**CITY OF ALBUQUERQUE
PLANNING DEPARTMENT**

DRB Comments

PROJECT # 1009567

RE: Lots 1-6, Block 10, Mesa Grande Addition

PLAT OF  
**LOT 6-A, BLOCK 10**  
**MESA GRANDE SUBDIVISION**

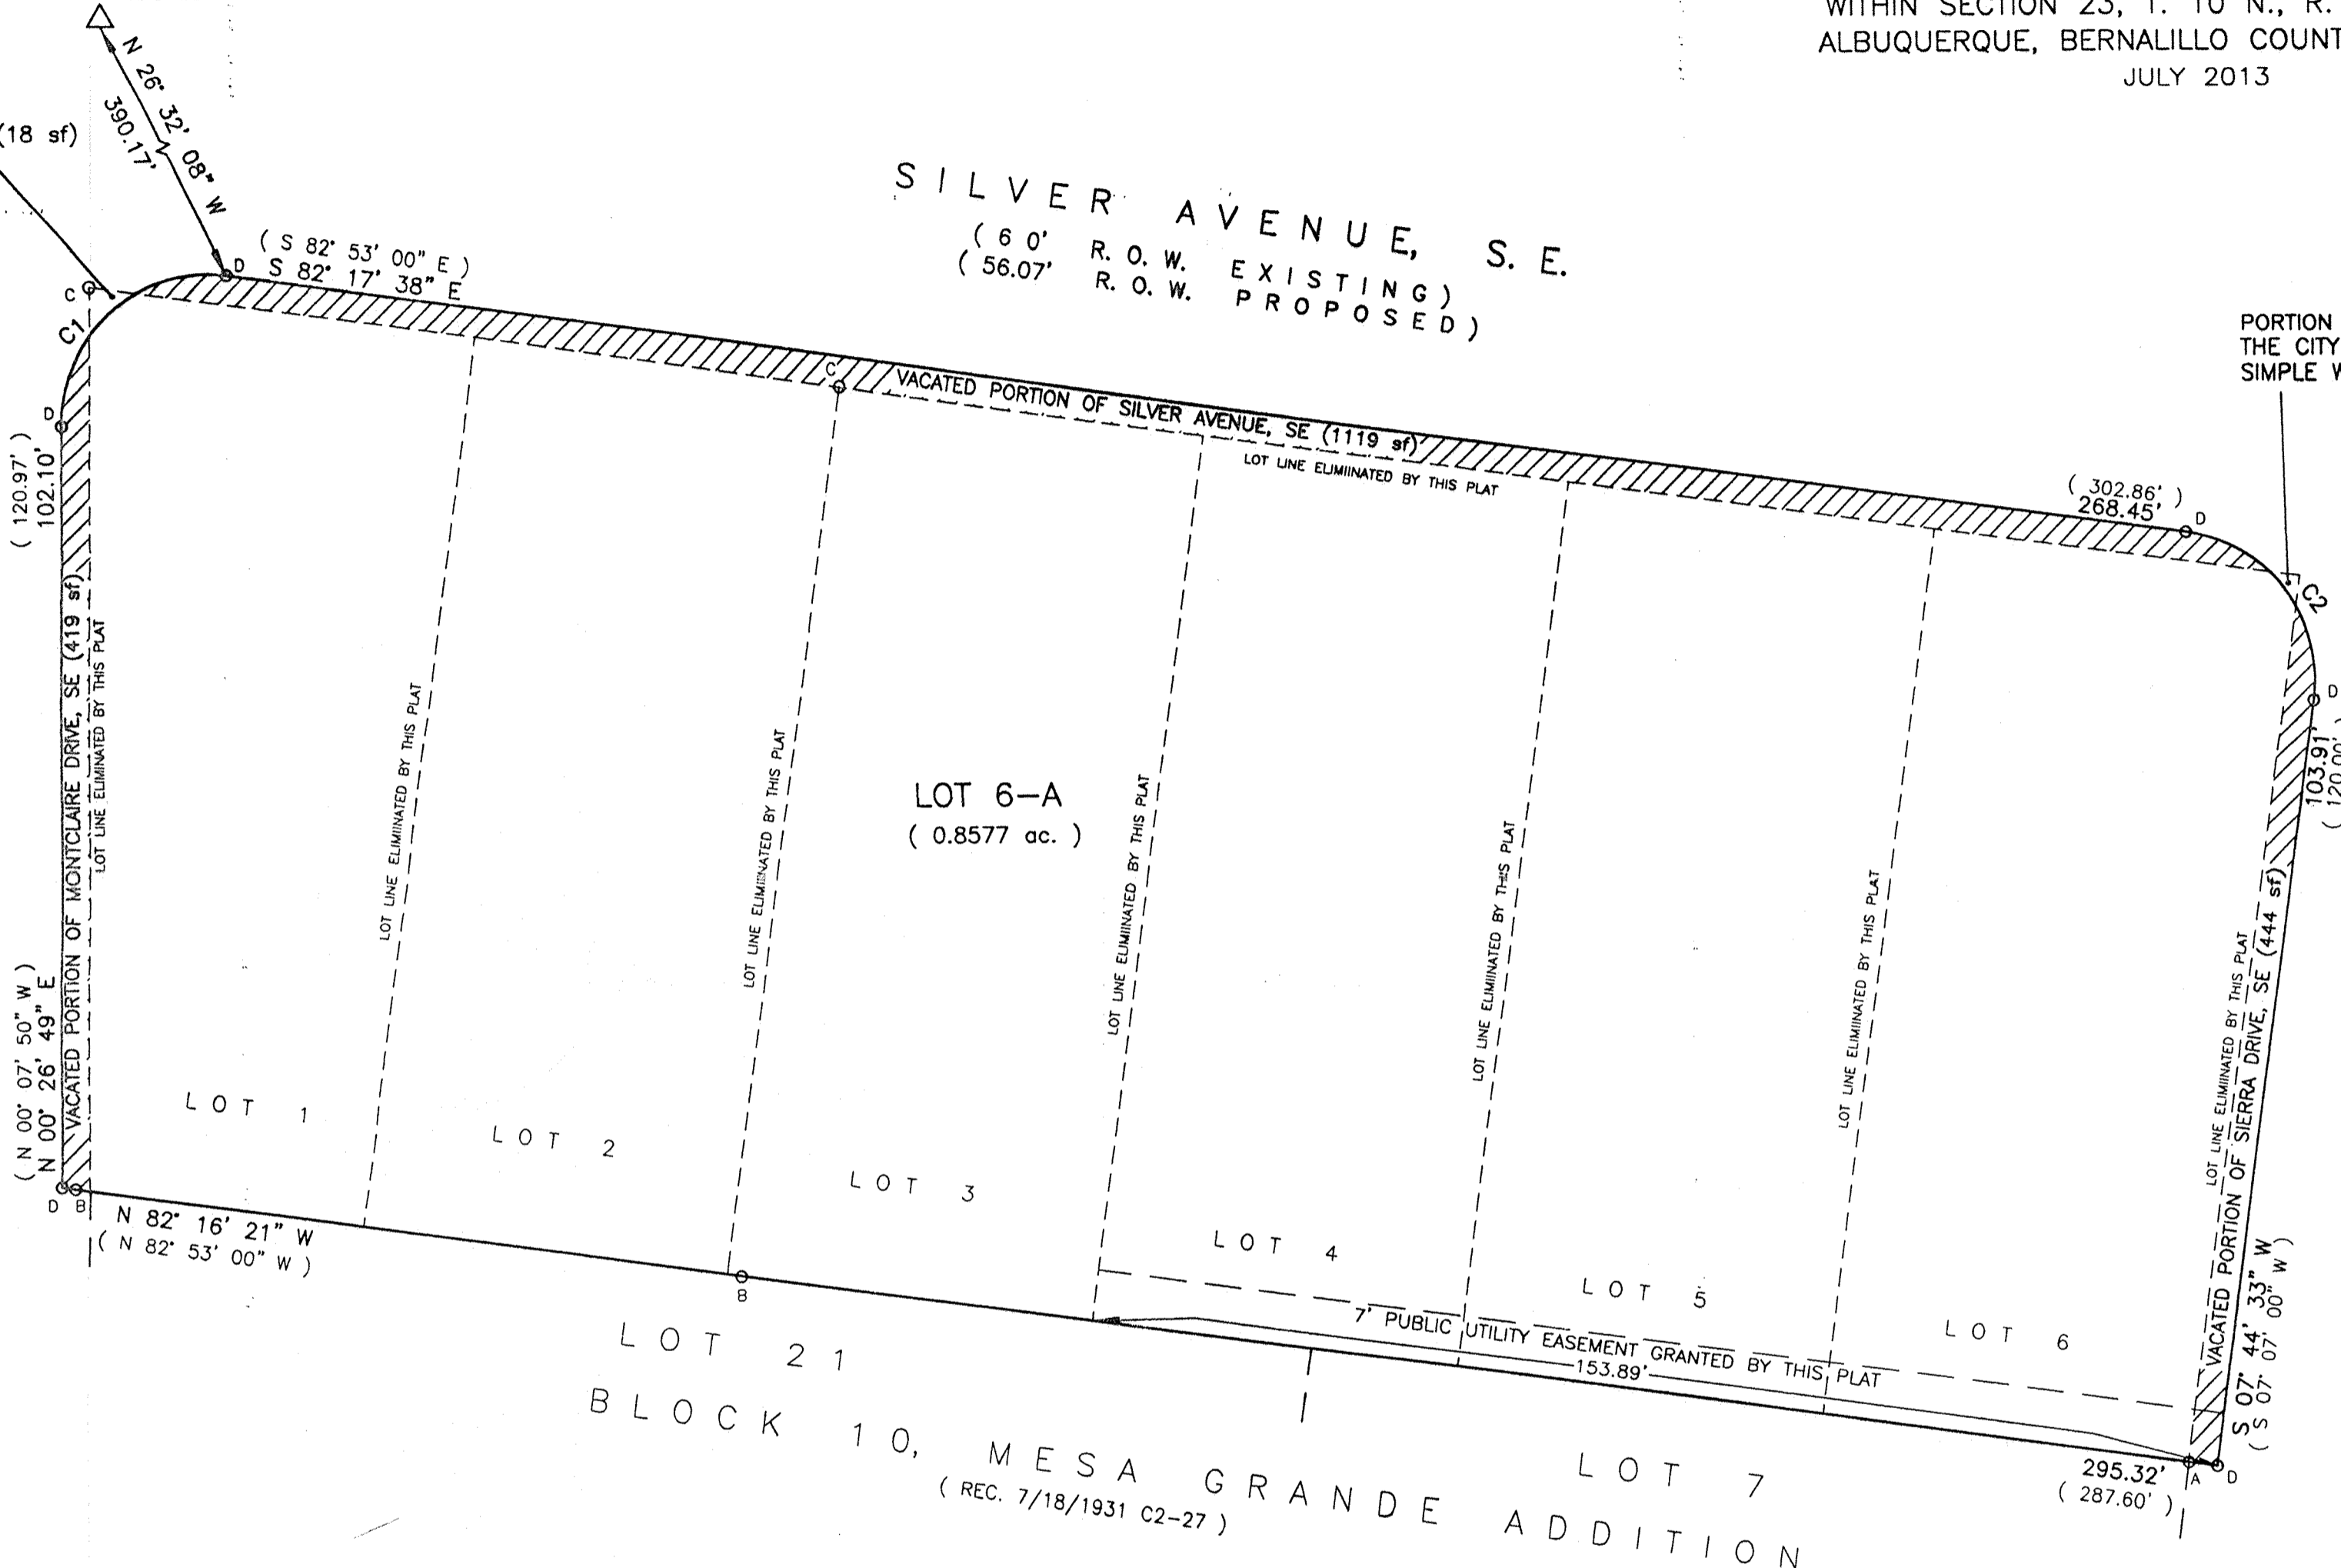
Vacation of public right of way requires appropriate application (Form V) with fee (total \$395) and an advertised public hearing per the Subdivision Ordinance; if approved, vacated right of way must be purchased from the City and incorporated into adjacent property via replat (\$235) within one year. However, the justification for the request is not consistent with City design standards, because sidewalks are within public right of way which would suggest additional dedication, not vacation. Refer to comments from Transportation Development, as it appears there may be excess right of way suitable for vacation, but not for widening sidewalks.
